Ref: EN010135/EH1.AS-301

Location: Stonestreet Solar Farm, Aldington
Proposal: Erection of a Solar Farm

We have reviewed this application in regard to Crime Prevention Through Environmental Design (CPTED) and in accordance with the National Planning Policy Framework (NPPF).

Drawing Title:  
Illustrative Fencing  
Detail  
Post And Wire

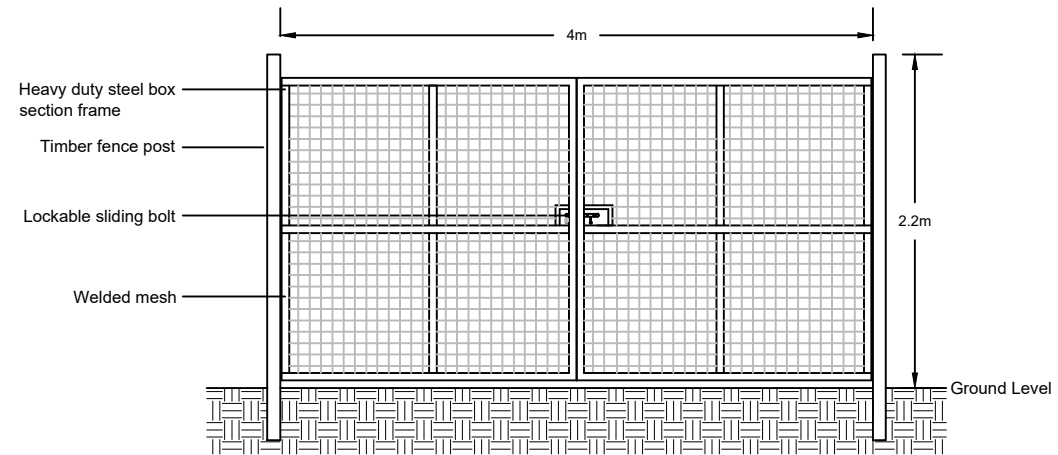
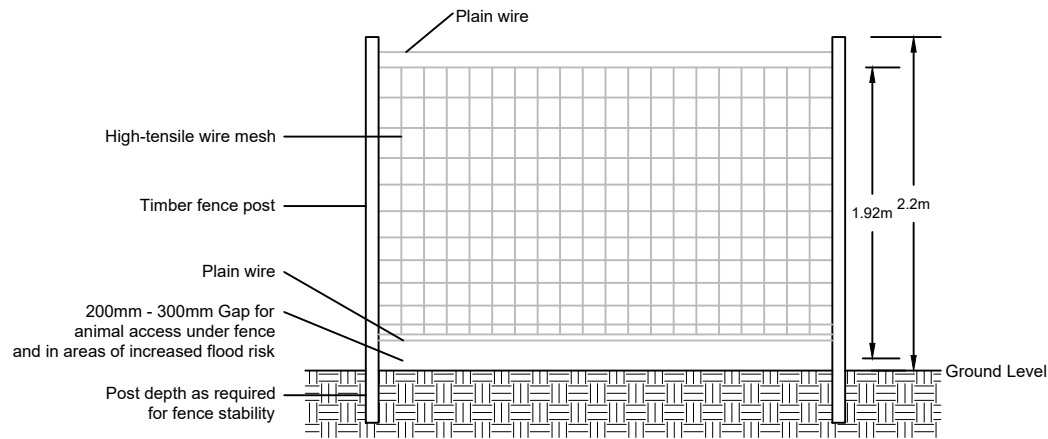
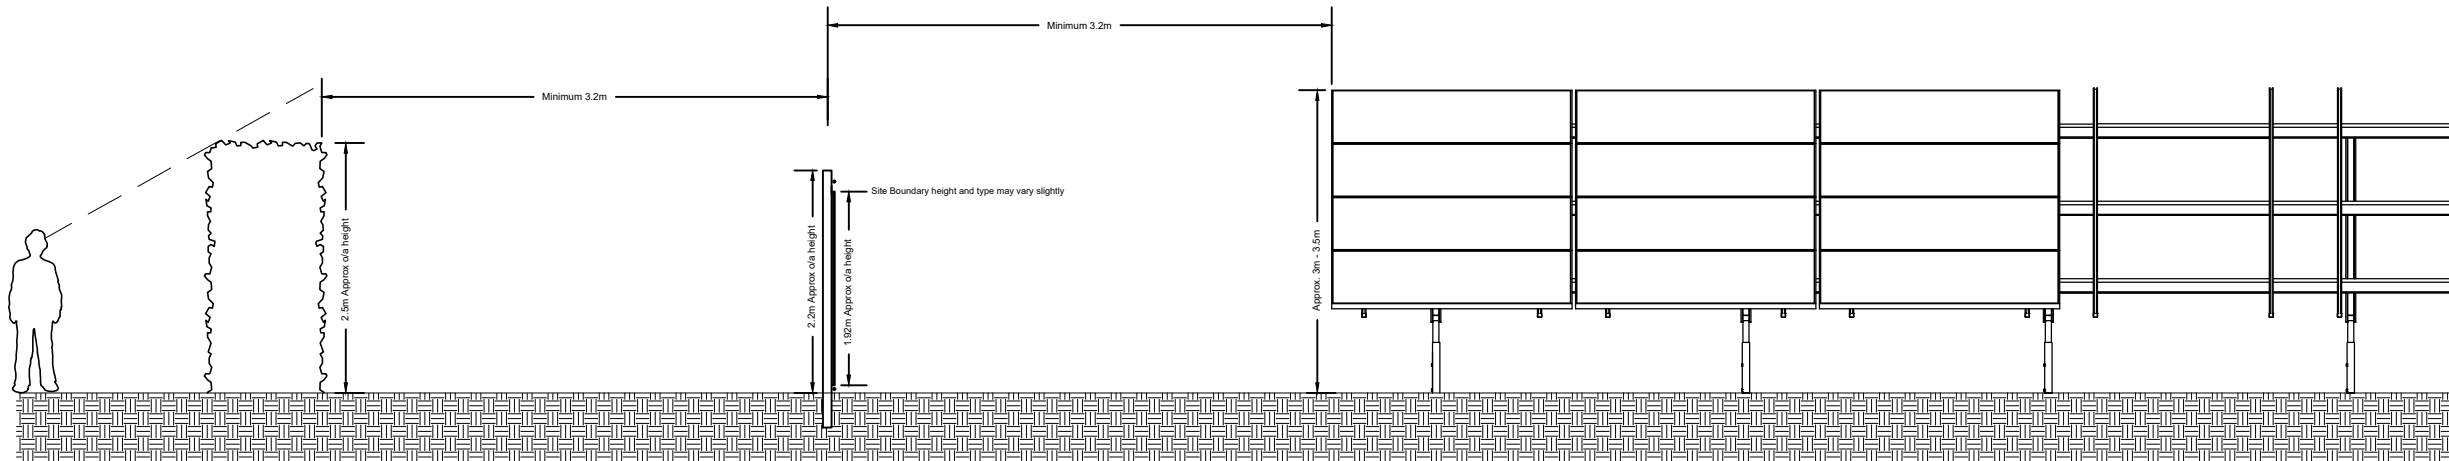
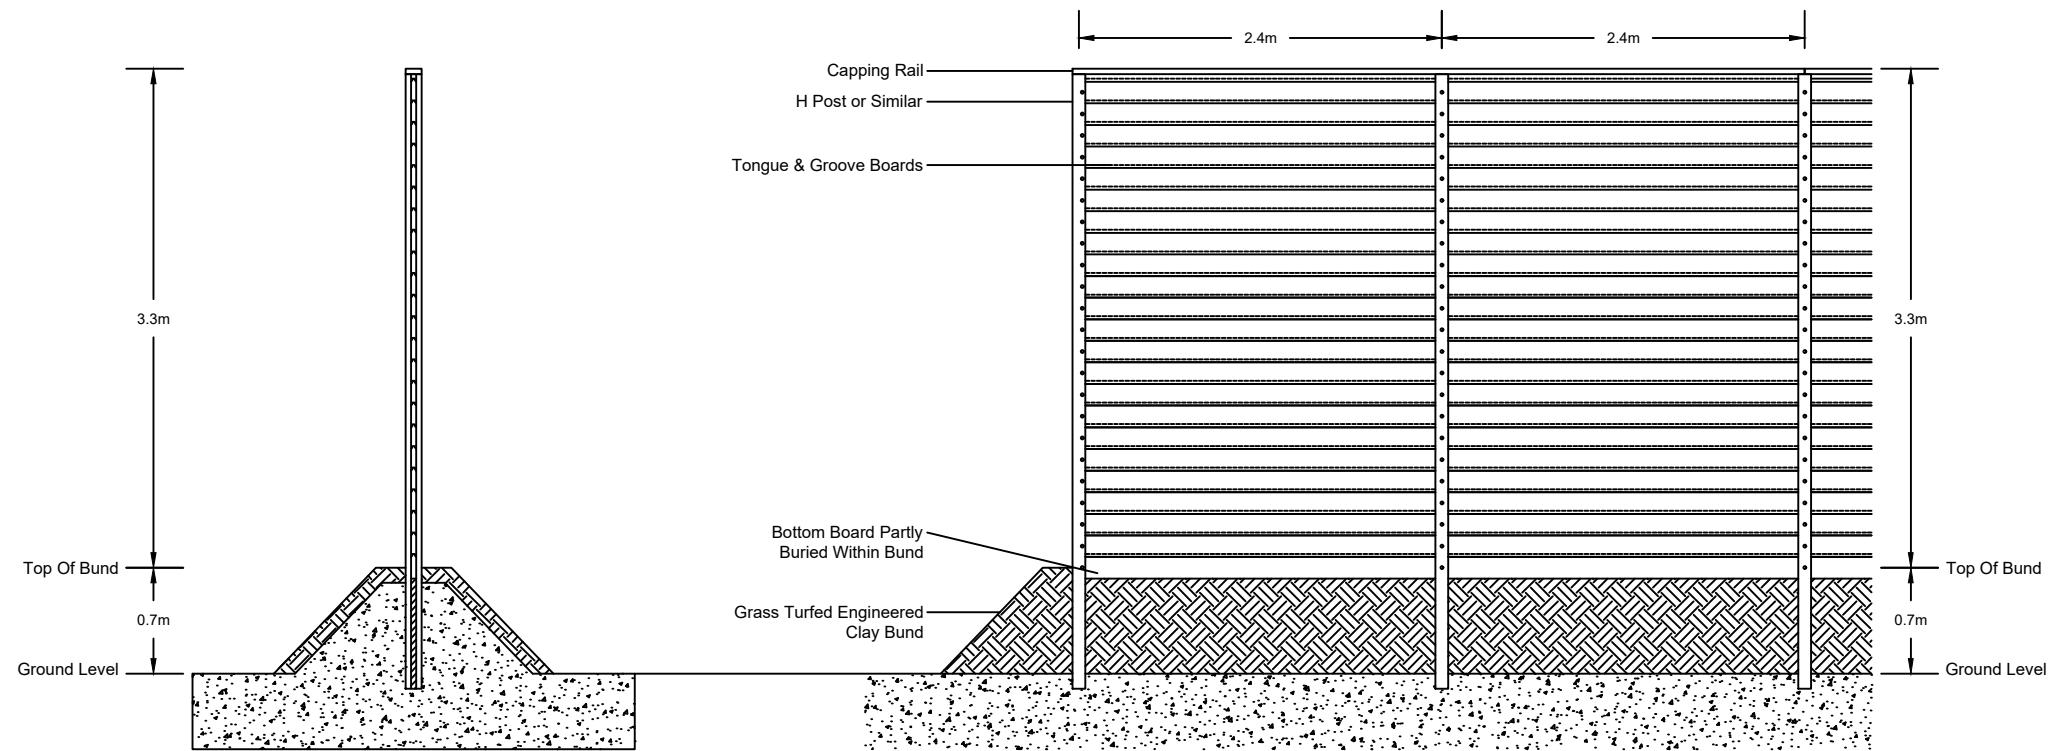
2. Perimeter security of the site, including gates, should be reviewed to control site permeability and prevent theft of property. A good standard of building security is very important in rural areas, especially for outbuildings that may not be visited for weeks at a time. Each site should be fully enclosed within a minimum 2m security fencing system or higher (we note the Indicative Fencing proposal). It is, however, important that the gap between the base of any fencing and the ground is minimal, so that any equipment, such as the PV panels themselves or copper cable, cannot be easily passed underneath by thieves. Additional defensive planting of natural hedging should be considered around the boundary and along the existing footpath as an added layer of security

- Additional defensive planting of natural hedging can also be considered around the boundary as an added layer of security.
- As detailed above, the site operational areas should be fully enclosed within a minimum 2m fencing system. It is however, important that the gap between the base of any fencing and the ground is minimal, so that any equipment, such as the PV panels themselves or copper cable cannot be easily passed underneath by thieves.

- Any public footpaths through the site of the arrays should be fenced to 2m on either side of the path.
- Given the large amounts of valuable equipment and copper cable likely to be on site during construction, it is essential that the main site and any smaller temporary compounds are secured with appropriate temporary alarms and CCTV systems, particularly if security guards are not to be employed during construction. Any tool containers, plant (e.g. excavators) and associated fuel bowsers/bunded fuel tanks should also be secured, alarmed and immobilised at the end of each working day.

Drawing Title:  
 Illustrative CCTV Specifications

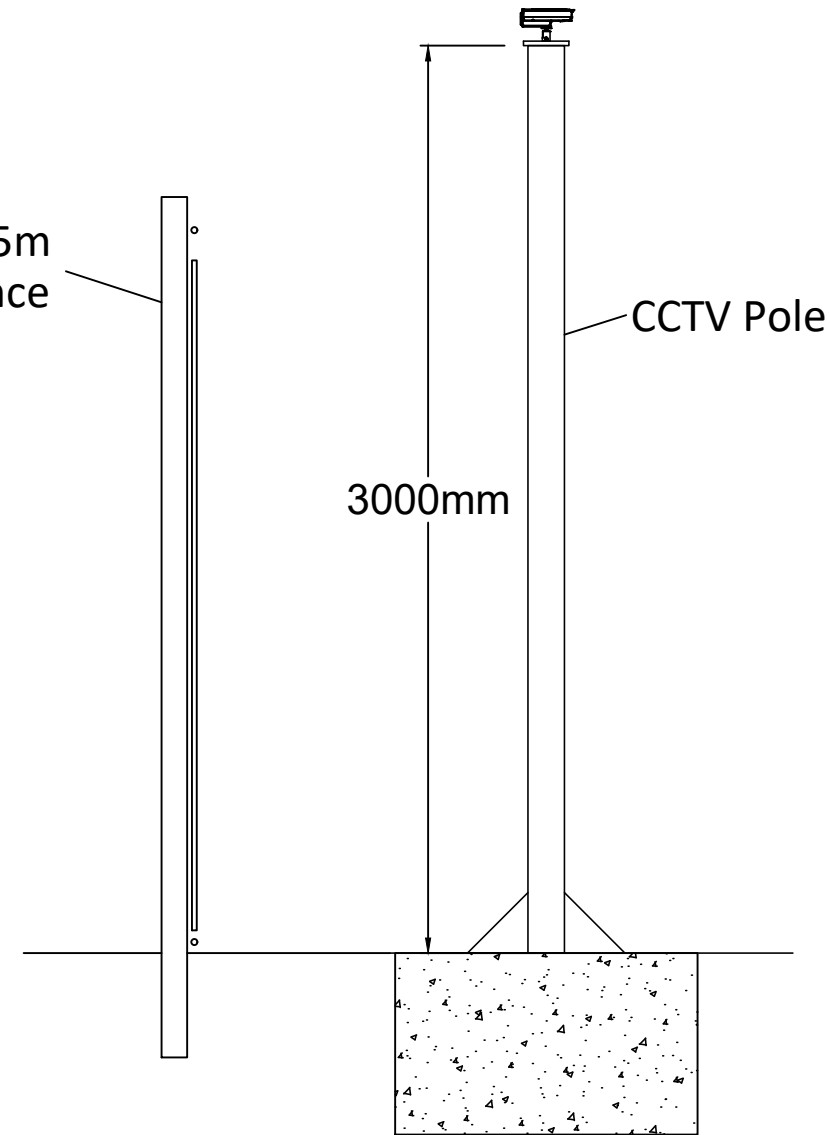
6. We note CCTV cameras are proposed for this development "Cabling would also be required for power and data transfer associated with the CCTV system described below. This would generally follow the perimeter fence lines where the CCTV cameras would be located", which is greatly encouraged. We recommend monitored CCTV and alarms systems to be installed and operational to cover vulnerable elevations and site entrances in addition to point 5. Appropriate crime prevention/security signage warning of the use of CCTV and forensic marking solutions should be installed on the exterior face of the security fencing and any gates.

- All electrical compounds, inverter, substation, transformer, battery and control buildings/cabinets to be fully alarmed with 24 hour monitored systems and covered by CCTV. We note that CCTV is being proposed as detailed above.
